February 19, 2013

**RE: Old Barn Estates  
Stormwater Management – Response to Review Comments.**

REV.	DATE	STATUS	BY	CHKD.	APPD.	REV.	DATE	STATUS	BY	CHKD.	APPD.
A	1/01/13	SUBMITTED TO CITY OF PORTLAND FOR WORKSHOP	DEPT.	PBB	TWS

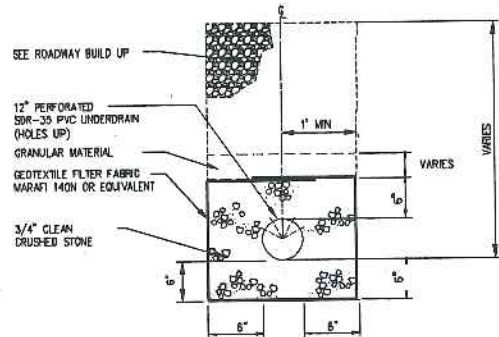
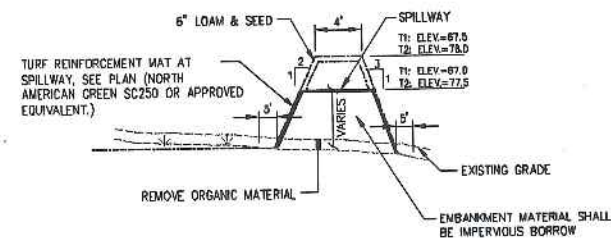
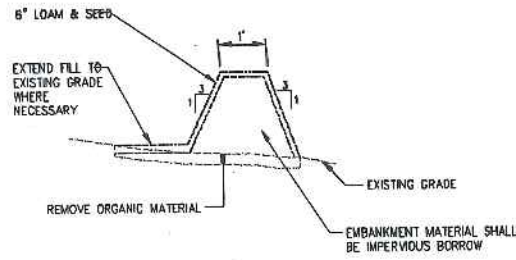
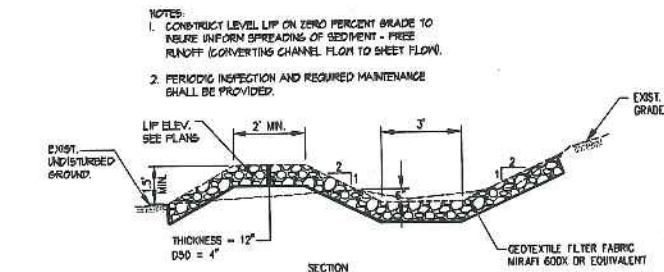
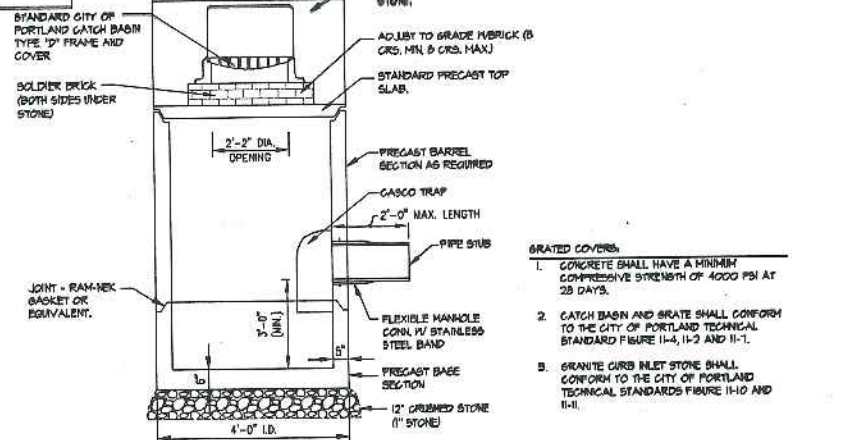
6. Sheet C-202: *CMP sizing noted as 36" here.*  
**The pipe is intended to be a 36" CMP.**
7. Sheet C-300: *Note D5 – Indicate contractor should run dewatering through a DirtBag or similar sediment barrier before discharge to wooded area.*

**The note has been updated on sheet C-300.**
8. Sheet C-300: *Note E1 – Reporting to be done by Contractor if they are State certified in Erosion and Sedimentation Control or by an independent third party inspector.*

**The note has been updated on sheet C-300.**
9. Sheet C-300: *Note E3 – Owner/contractor shall retain design engineer or qualified third party to inspect/document construction of the UDSF's.*

**The note has been updated on sheet C-300.**
10. Sheet C-300: *Please provide an overall sequence for construction indicating sequence for installing E&SC measures and emphasizing protection of UDSF's until contributing drainage areas are stabilized.*

**A construction sequence has been added the plan.**
11. Sheet C-300: *I/O Protection detail updated with 36" culvert data if appropriate.*  
**The I/O protection detail has been updated to provide data for the 36" culvert.**

1 TYPICAL EMBANKMENT/SPILLWAY DETAIL
SCALE: N.T.S.

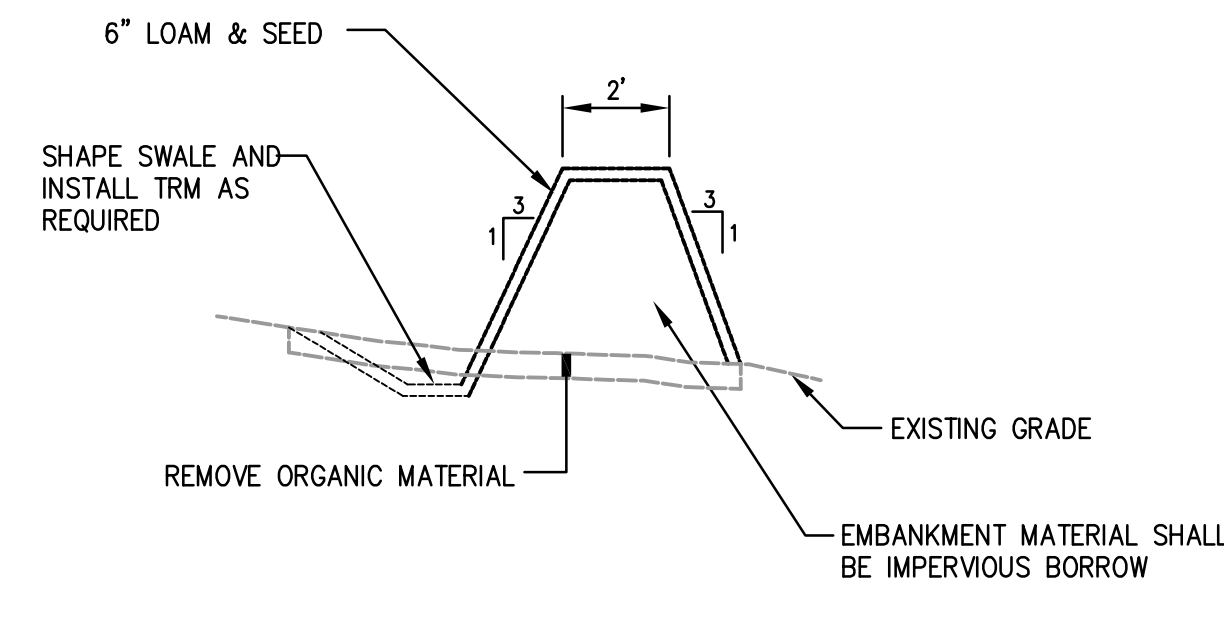
12. Sheet C-302: *Spillway detail – please identify 2H:1V slope as requiring EC blanket.*  
**The information has been added to the detail.**
13. Sheet C-302: *Table 7-2 – Delete Option 2 Note? Table 7-3 – Delete Table?*
